Our Ref: AL/1/18/HH
Your Ref:

Town & Country Planning Act 1990 (as amended)
Town & country Planning (Development Management Procedure) (England) Order 2015
Application for Planning Permission for Works or Extension to a Dwelling

Development Single storey rear pitched roof extension with extension to open front porch & permeable paving to front garden area to replace existing concrete.
Location 14 Elmcroft Place Westergate

14, Elmcroft Place,
Westergate,
West Sussex,
PO20 3XL

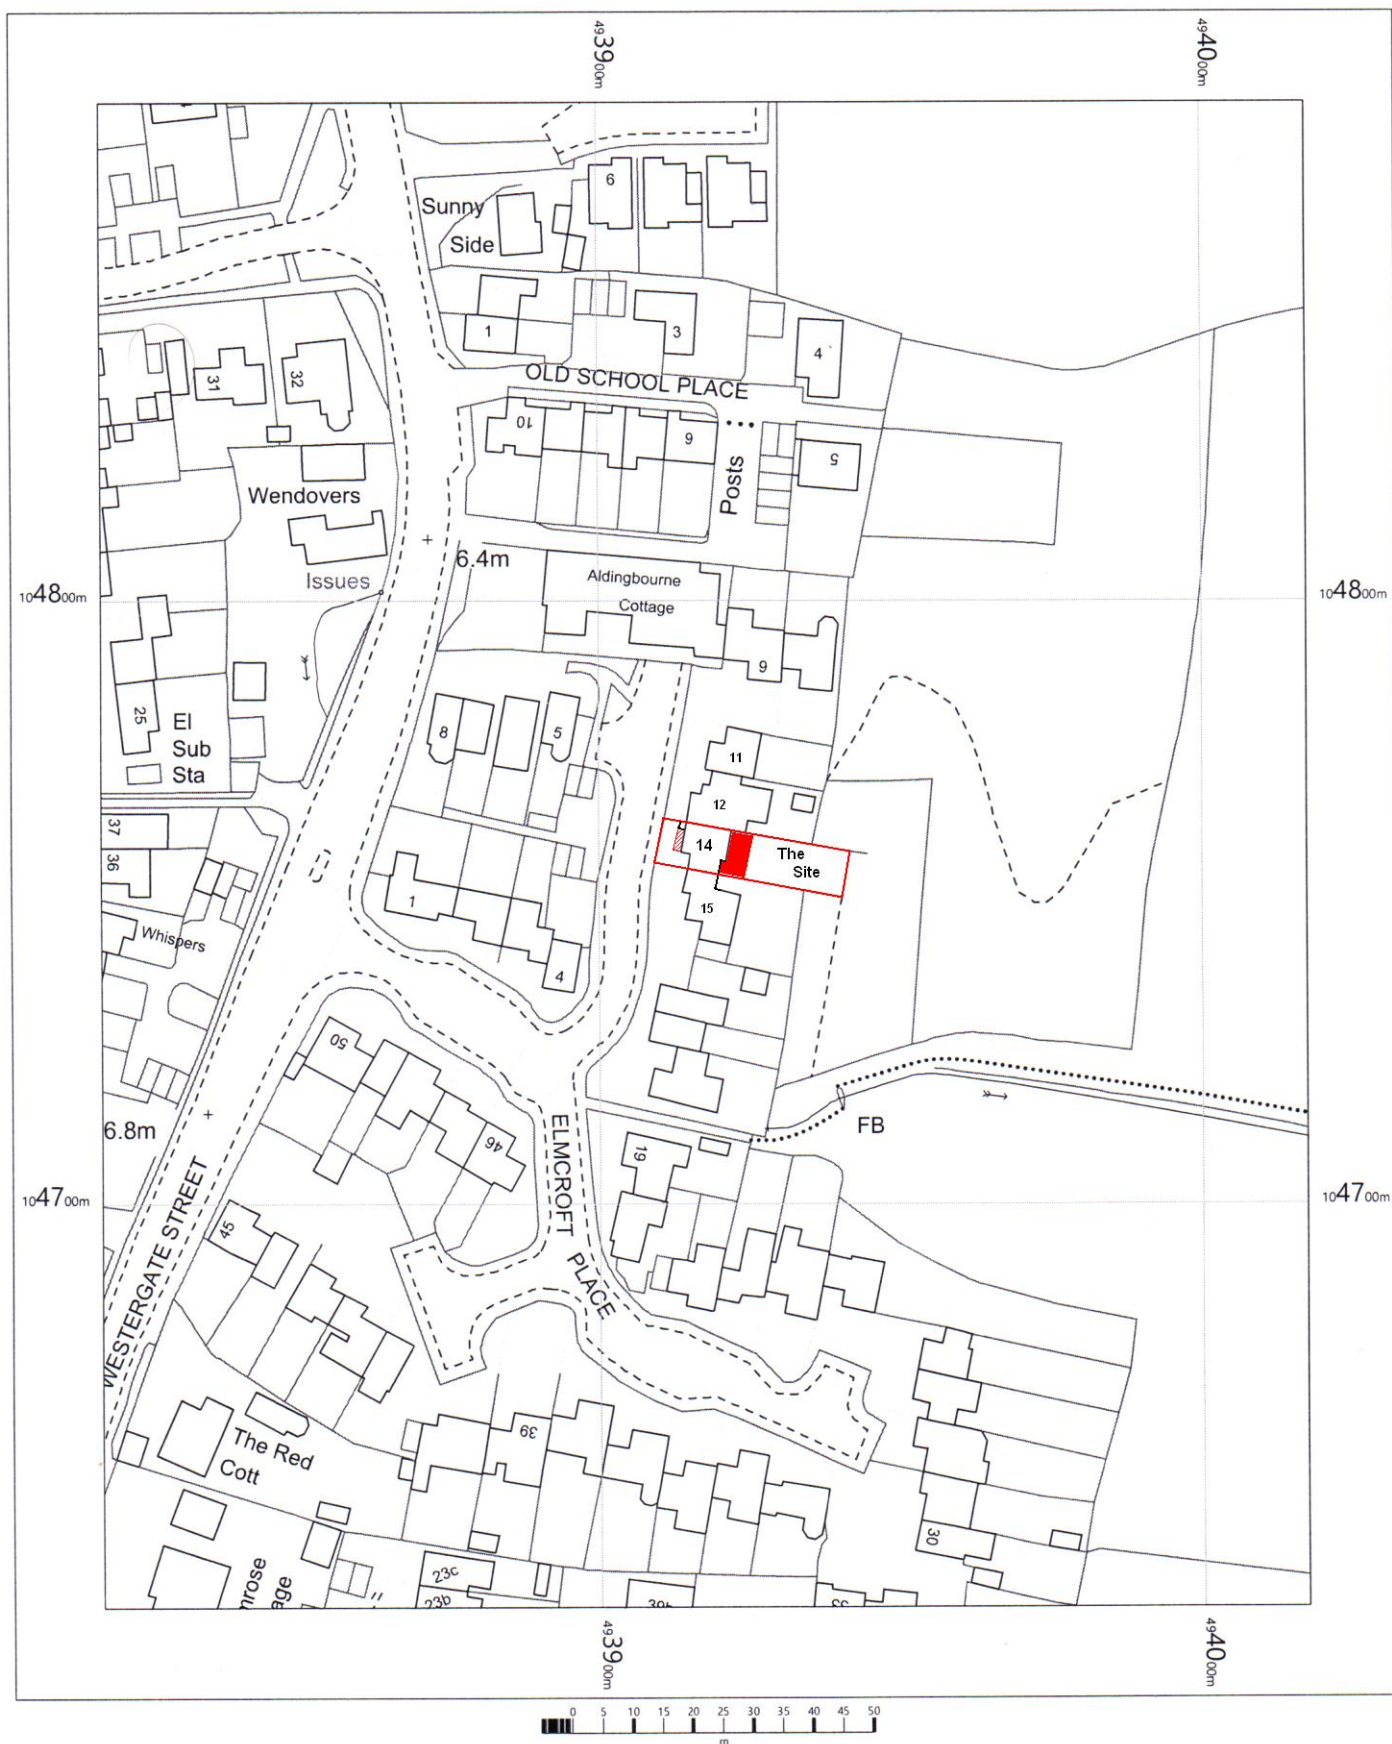
Location Plan

Please submit 1 electronic or 3 paper copies of a location plan at a scale of 1:1250 or 1:2500 for rural areas. Further details of what must be included on the plan can be found in the National Validation Requirements.

Proposed
Block Plan 1:500

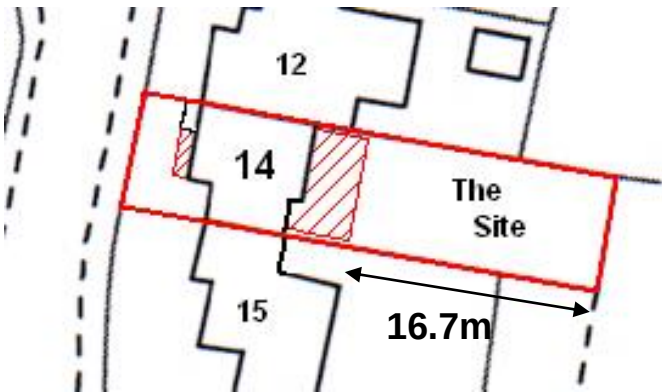
Block Plan Amend

Please submit 1 electronic or 3 paper copies of a block/site plan at a scale of 1:500 or 1:200. Further details of what must be included on the plan can be found in the National Validation Requirements. Please provide a measurement from the proposed rear extension to the rear boundary.
